Planning Application Ref: BN/65/19/OUT

Location: Bexstone House, Barnham Road, Eastergate, PO20 3RT

Description of works: **Outline application with some matters reserved for the demolition of existing dwelling & erection of 10 No. new dwellings, widening & reprofiling of site access, provision of a right turn lane with improved visibility splays, retention of significant landscaped highway buffer, parking for 30 No. cars including garages & visitor parking & potential future highway access to adjacent housing land (resubmission following EG/49/18/OUT).**

MAP FILENAME : **Bex/TSP/01/18**

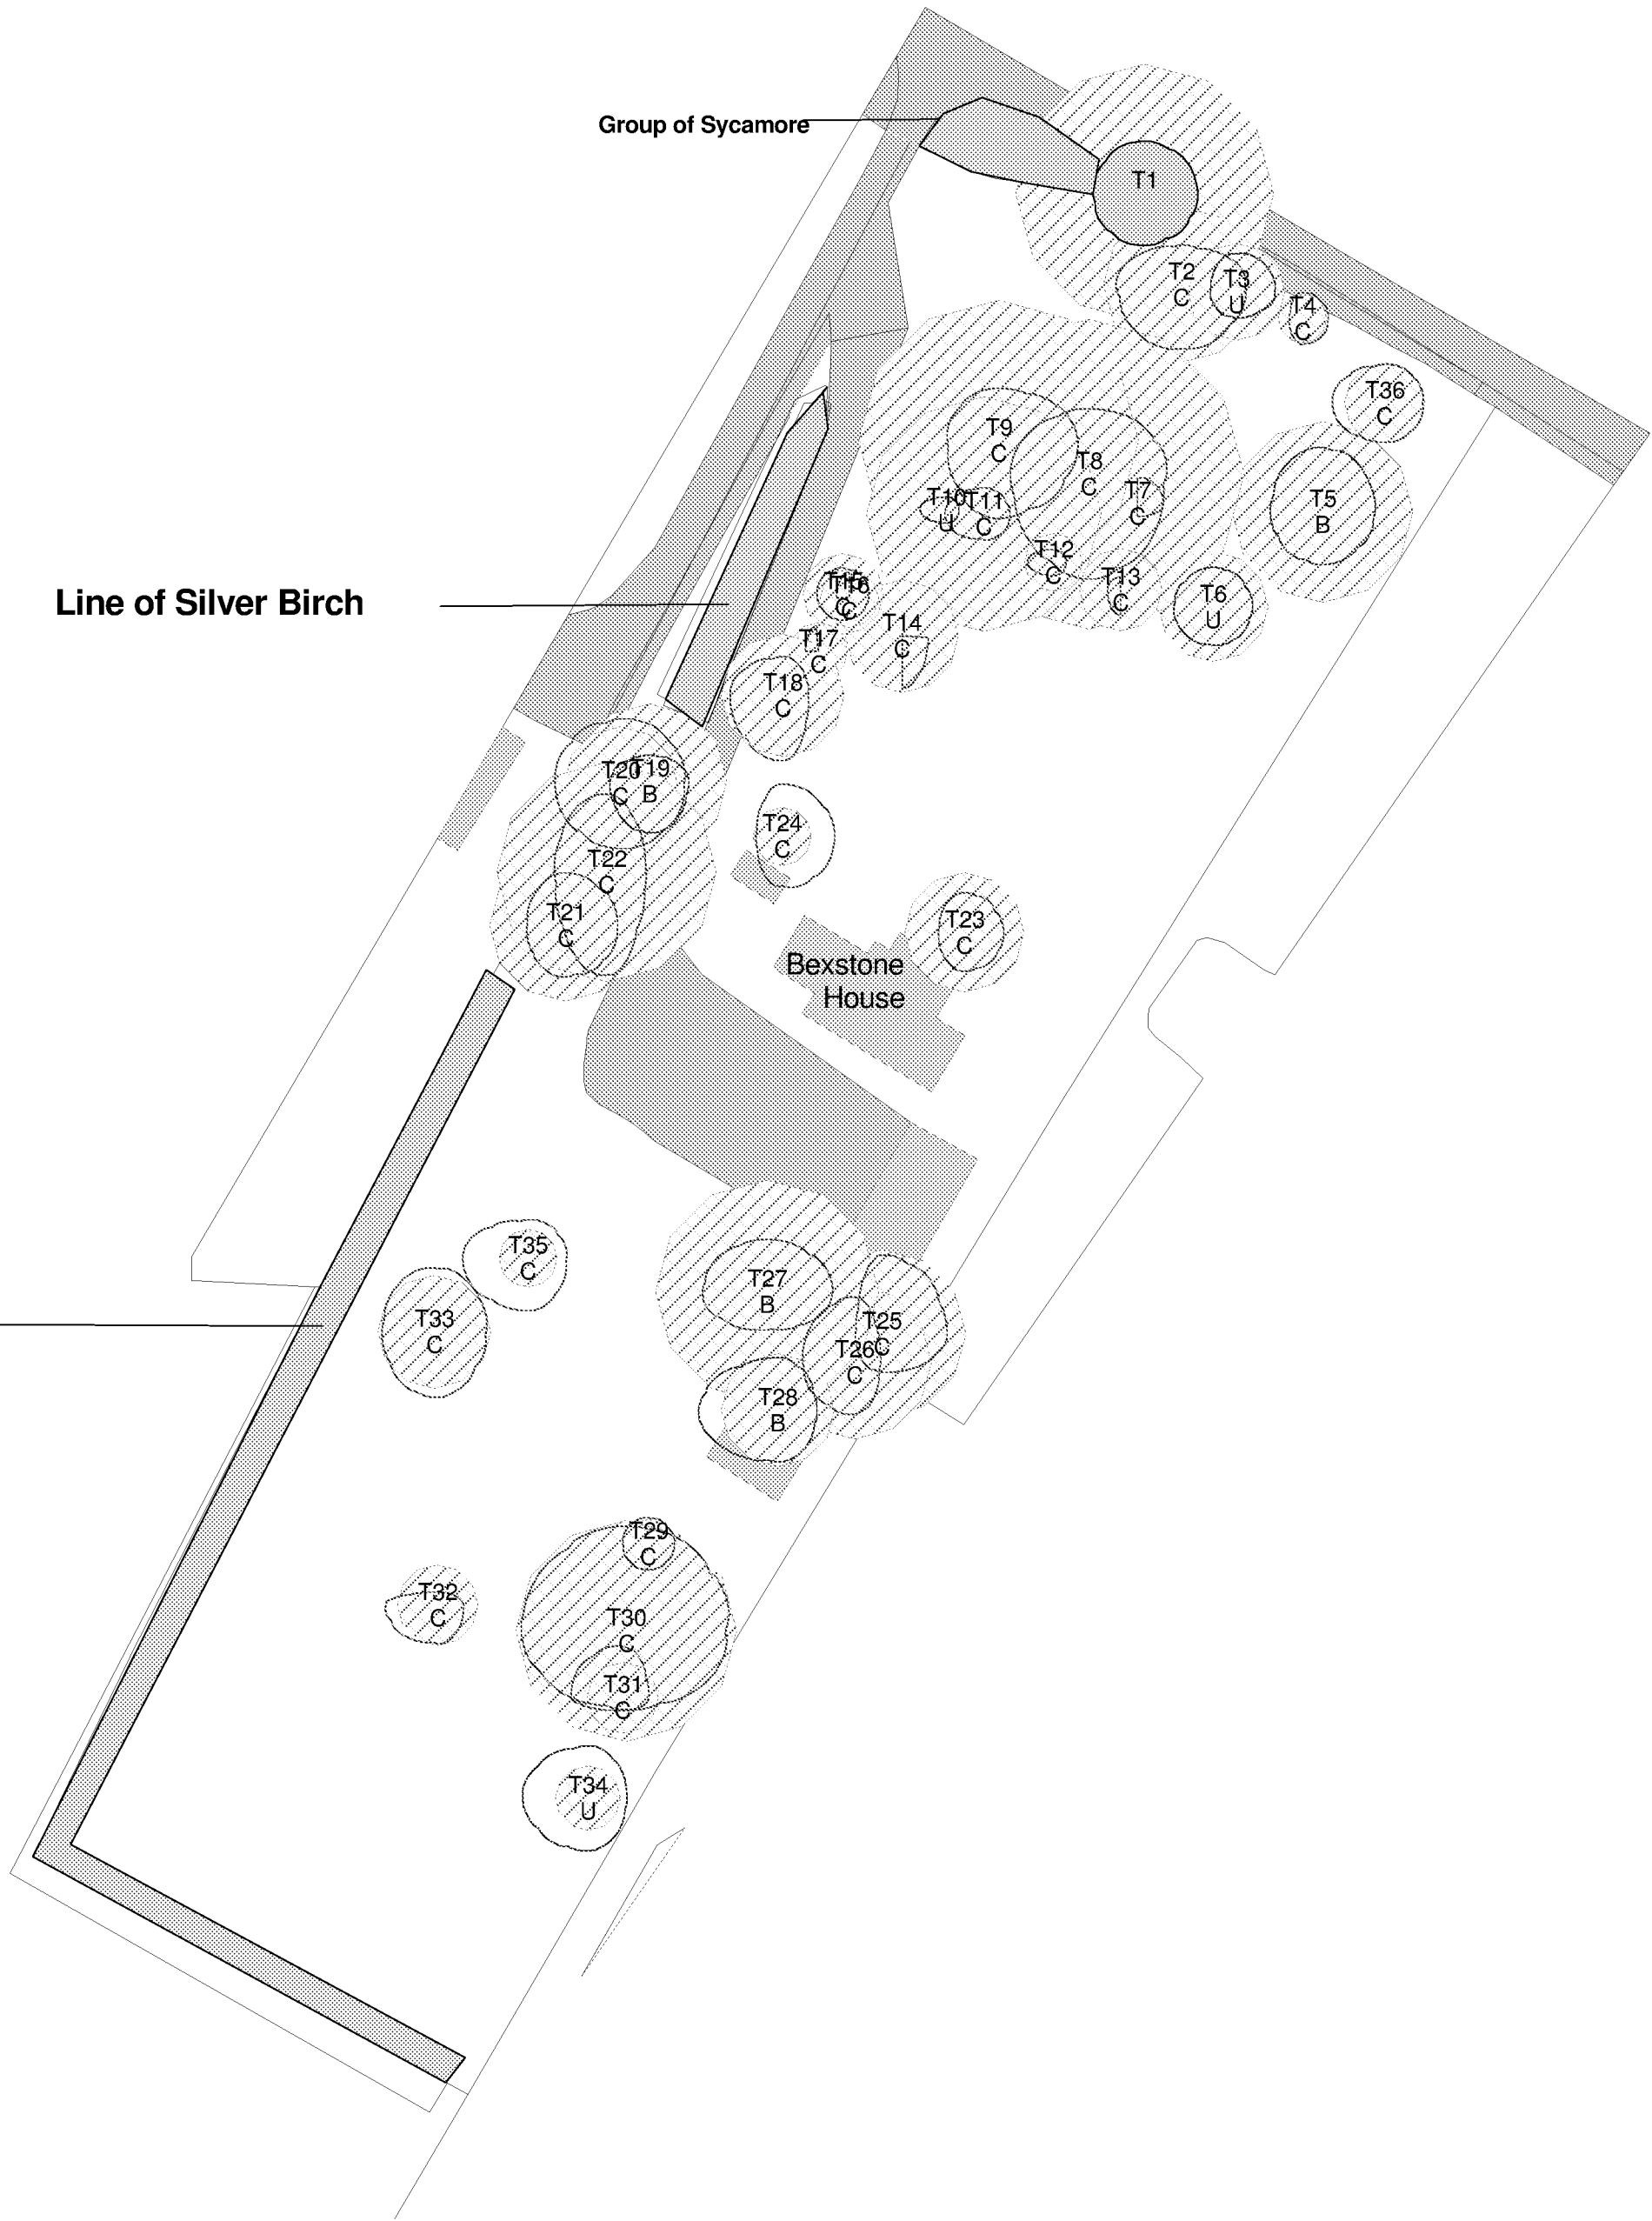
- The applicants have employed Richard Jackson | Arboricultural Consultant to prepare a Tree Survey Plan for this project. This has been submitted in monochrome format and with no supporting Arboricultural Report inclusive of Tree Survey Schedule, Root Protection Area Schedule and Constraints Plan.

- The arboricultural information provided so far, fails to adequately inform the application process and clearly does not accord with the requirements of BS5837:2012.

1. The applicants will need to employ the services of an Arboricultural Consultant to carry out a tree survey exercise and then prepare an Arboricultural Impact Assessment (AIA) which must be inclusive of; a 'Tree Survey Schedule', a 'Root Protection Area (RPA) Schedule' and a 'Tree Constraints Plan' – with the trees accurately plotted on same.
